Application for DCO by FOSSE GREEN
Representation by Interested Party reference [REDACTED]
Deadline 2

Comments on REP1-047 Applicant's response to Written Representations

Figure 11-1

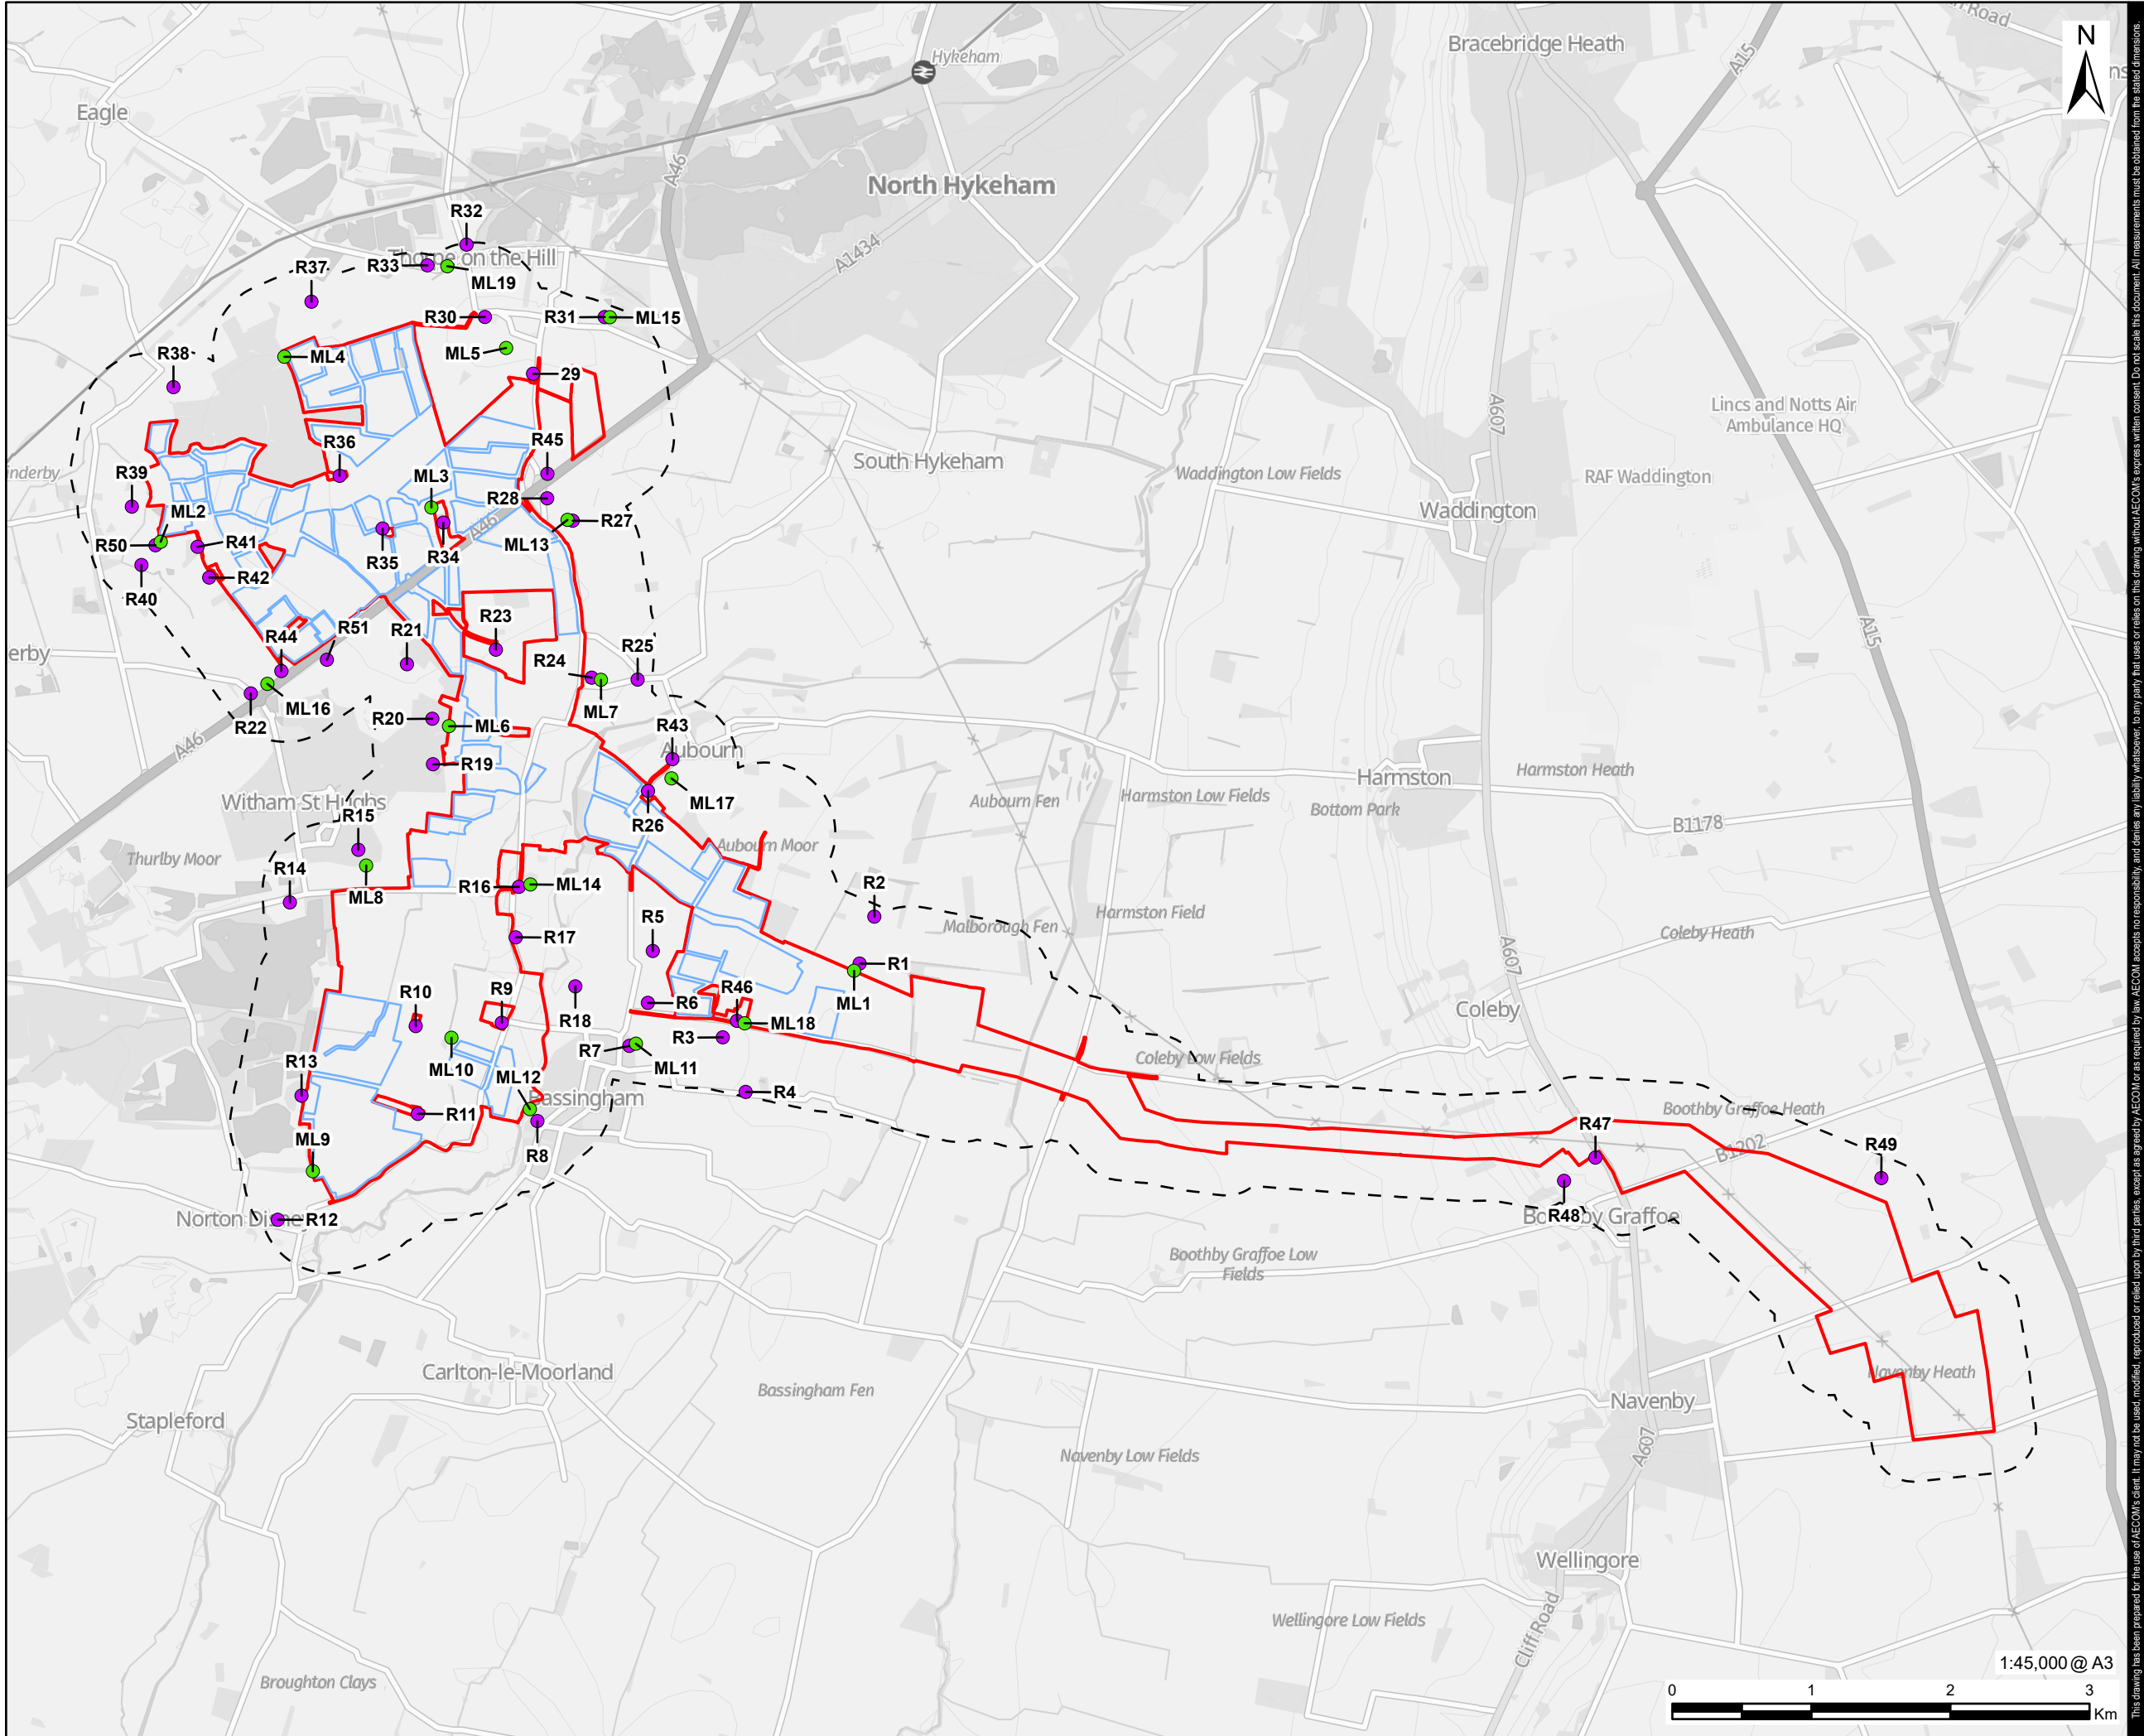
7.2.3 The Applicant asserts that the levels of operational noise along the PRoW of between 30dBA and 50dBA are akin to the existing sound environment as evidenced by the baseline sound surveys given in Table 11-12 of Chapter 11 Noise and Vibration (APP-036). However, none of the monitoring locations for the sound surveys were on the ProW. The purpose of the sound surveys was to assess noise levels at noise sensitive receptors, not PRoW as these had been scoped out of the EA. The position of the monitoring locations for the sound surveys is at Fig 11-1 Receptor and Noise Monitoring Locations (APP-099). The closest monitoring locations to the Thorpe on the Hill Stepping Out Walk footpaths are ML3 adjacent to the Cathedral View Holiday Caravan Park, ML5 close to the village of Thorpe on the Hill and ML4, close to a farm and vehicular track. The closest monitoring location to the stretch of footpath from Bassingham towards Aubourn (along LL/Bass/22/1, LL/Bass/21/2, LL/Bass/21/3 and LL/Aubo/8/1) is ML18 adjacent to a residential property along Fen Lane, a public highway open to all traffic. Noise levels measured at these locations will inevitably be higher than on the ProW network which are away from roads and residential properties.

The Applicant has therefore no evidence to substantiate their claim that the existing sound levels along the PRoW are akin to between 30dBA and 50dBA.

Figure 15-4

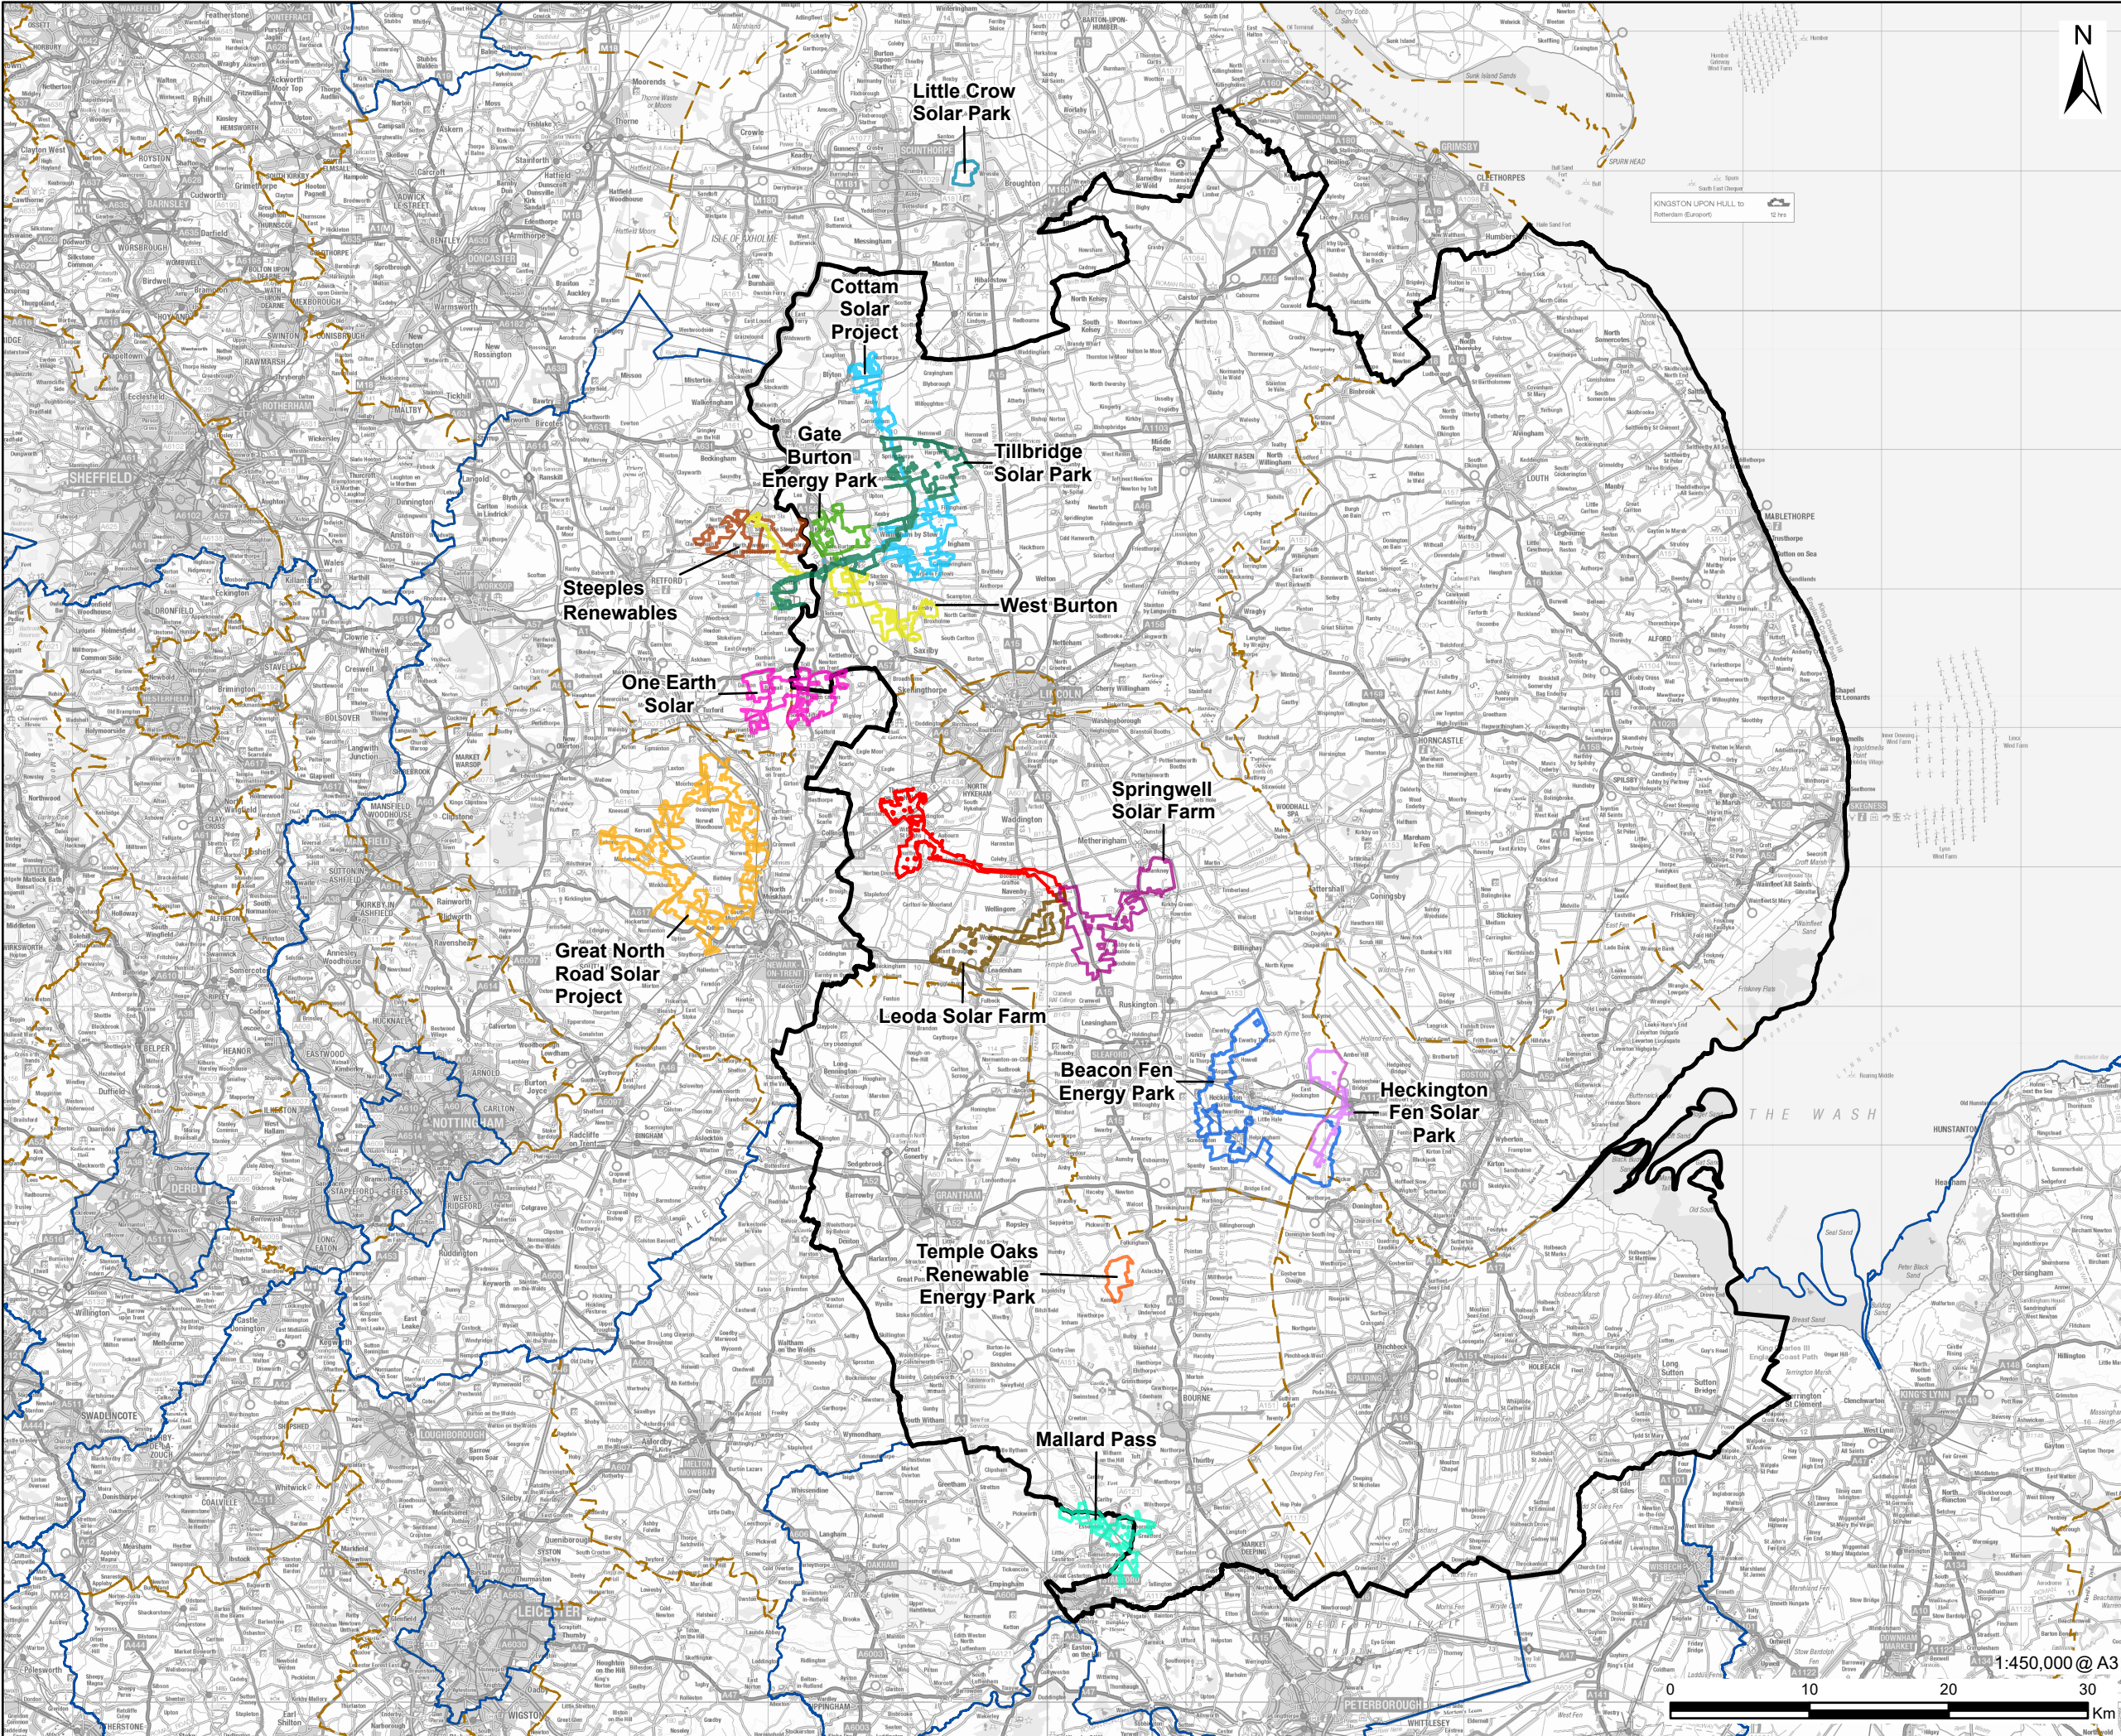
2.2.1 The purpose of the Joint Interrelationship reports as they relate to cumulative impacts is for the developers of each scheme to review the information and assessment made in relation to other projects and consider whether there are any changes to the assumptions and conclusions on their own cumulative impact assessments. The basis for the assessments of the cumulative landscape and visual impacts in relation to the schemes referred to by the Applicant was not accepted by the ExA in the Tillbridge and West Burton schemes as set out below. The Springwell ExA report has not yet been published.

2.2.2 The ExA Recommendation Report for Cottam (dated 5 June 2024) noted at paragraph 3.6.70 that there was limited intervisibility between the proposed development and other cumulative developments, and that there would be some changes to land use over a large area which would be seen in the context of an extensive agricultural landscape. The ExA did not agree that it would create an "energy" landscape. However, it does not appear that the concept of the sequential approach of visual receptors travelling through the landscape and experiencing multiple schemes across several kilometres was either put to or considered by the ExA.

2.2.3 In the subsequent examination of the Tillbridge and West Burton schemes, the sequential approach was considered by the ExAs. In the ExA Examination Report for West Burton dated 8 August 2024, it was noted at paragraph 3.3.97 that the applicant's LVIA "underestimates the potential for cumulative sequential visual impacts" and at paragraph 3.3.98 that "the focus of the Applicant's LIVA assessment on the intervisibility between solar schemes and therefore combined views does not fully acknowledge the potential landscape and visual effects of the spread of considerable, albeit dispersed, solar development across an extensive area". At paragraph 3.3.106 the ExA concludes that the extent of the proposed

solar NSIPs, along with other proposed solar development across the district and beyond raises concerns about their potential combined effect on the landscape character of a wide area as well as cumulative sequential visual impacts.

2.2.4 The ExA Recommendation Report for Tillbridge dated 14 July 2025 says at paragraph 3.7.133 that “we consider that the Applicant’s focus on specific viewpoints neglects the sequential cumulative effects experienced when receptors move through the landscape” and concludes at paragraph 3.7.145 that “overall, we attribute great negative weight to the landscape and visual harm which would be caused by the development in isolation, and when considered cumulatively with other developments”.
